From:
Sent: 24 June 2024 20:15
To: DCAdmin
Subject: Planning Objection - 2024/91484 - Erection of Poultry Shed, Bolster Moor Farm, Bolster Moor
Attachments: Planning Objection - 2024-91484 - Erection of Poultry Shed, Bolster Moor Farm.docx

Objection to Planning Application Number 2024/91484

HAIGH, PROPOSED POULTRY BUILDING  
AT 33 BOLSTER MOOR FARM,  
GOLCAR, HUDDERSFIELD, HD7 4JU  
FLOOR PLAN AND ELEVATIONS  
1:100 @ A4 MAY 2024

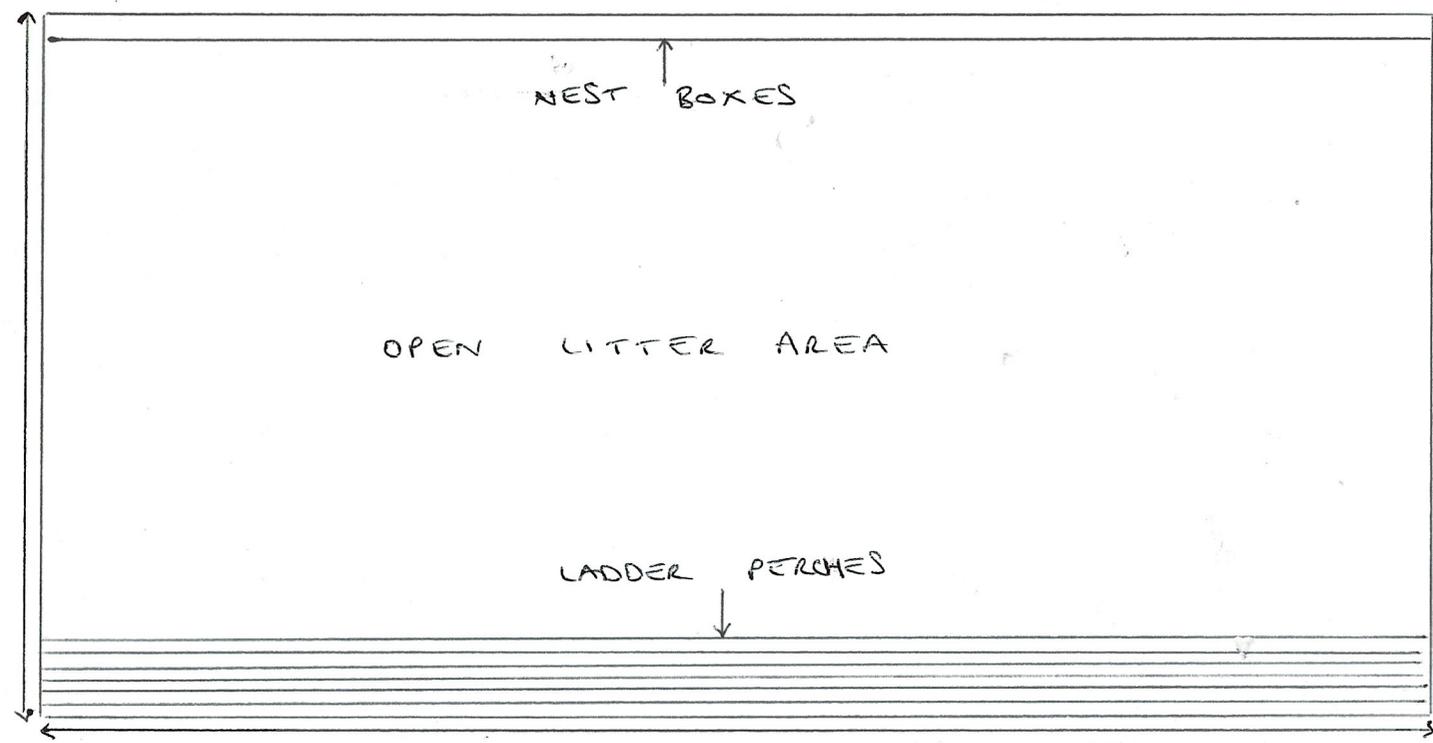
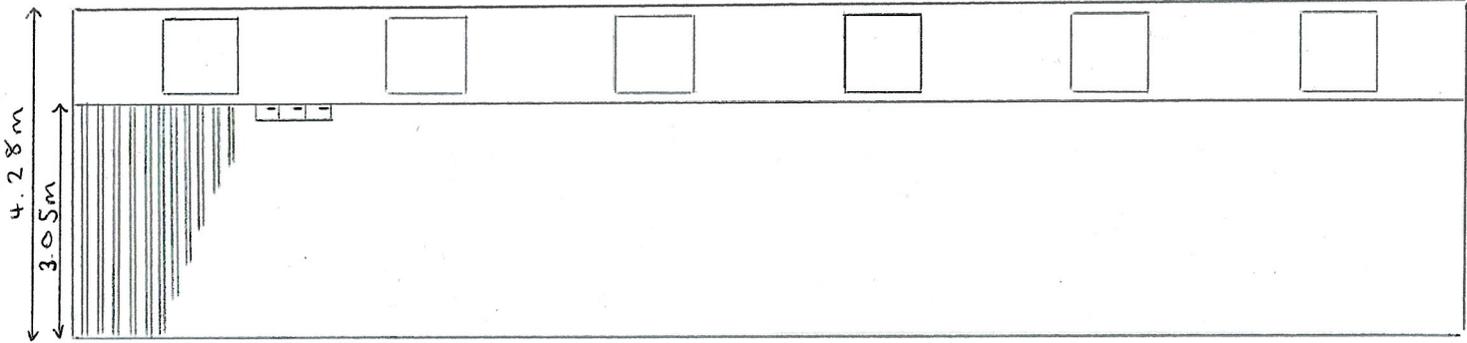
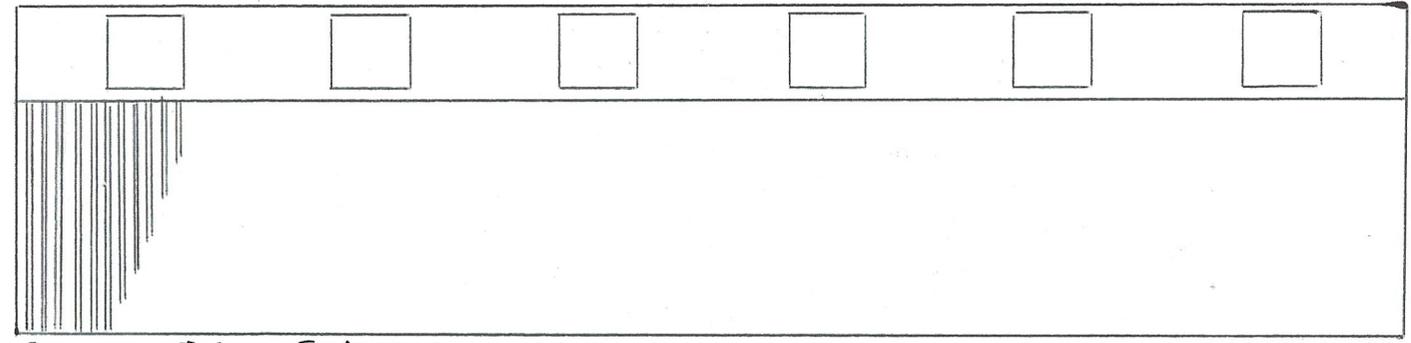
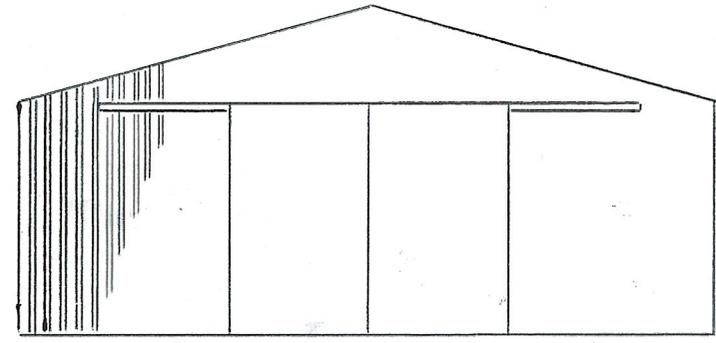
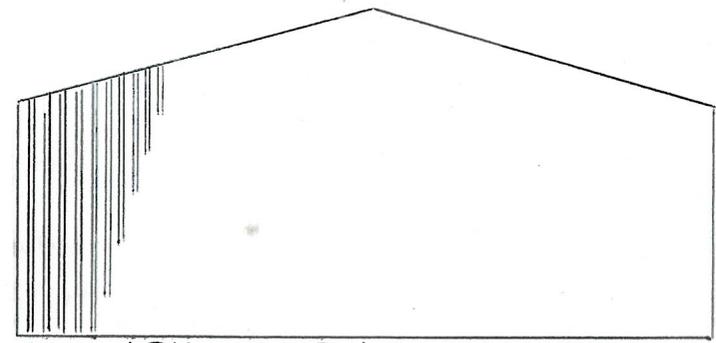
There is no mention in the application as to how any floor will be constructed. This leads me to believe that no artificial floor will be put in, instead the unit will sit directly on the soil. This will mean that pollutants from the chicken excrement will leach into the soil and will be washed down the slope and into the groundwater and land drain, particularly during deep cleaning at the end of a production cycle when any pollutants will be jet washed into the ground. This land drain already struggles to contain water during periods of heavy rainfall, causing localised flooding across residents’ properties and affecting a garden pond. This additional runoff will simply add to the existing and frequent effluent runoff from the applicant’s property already affecting residents. Any pollutants entering this watercourse will have an adverse effect on numerous wildlife, and will obviously affect the quality of the drinking water for animals on farmland.

The application does not show a double door entry system with a separate chamber to isolate the poultry from the outside world. Where will the applicant place the foot dip and his items of clothing to wear when dealing with the poultry? How will the applicant prevent 1,500 hens from escaping from the unit whenever the “12 foot steel sliding door” is opened? There are no details in the application concerning these points. The application is for barn hens, which by definition are kept inside. Residents already have problems with the applicant’s current hens escaping from his property and wandering round the area, defecating on pavements and destroying garden plants. Even during this consultation period the applicant’s hens have, once again, escaped and damaged gardens.

Over the production cycle of the hens, there are bound to be deaths. The application makes no mention of the quarantining of replacement birds and no mention of where this would happen. The plan shows a single space shed.
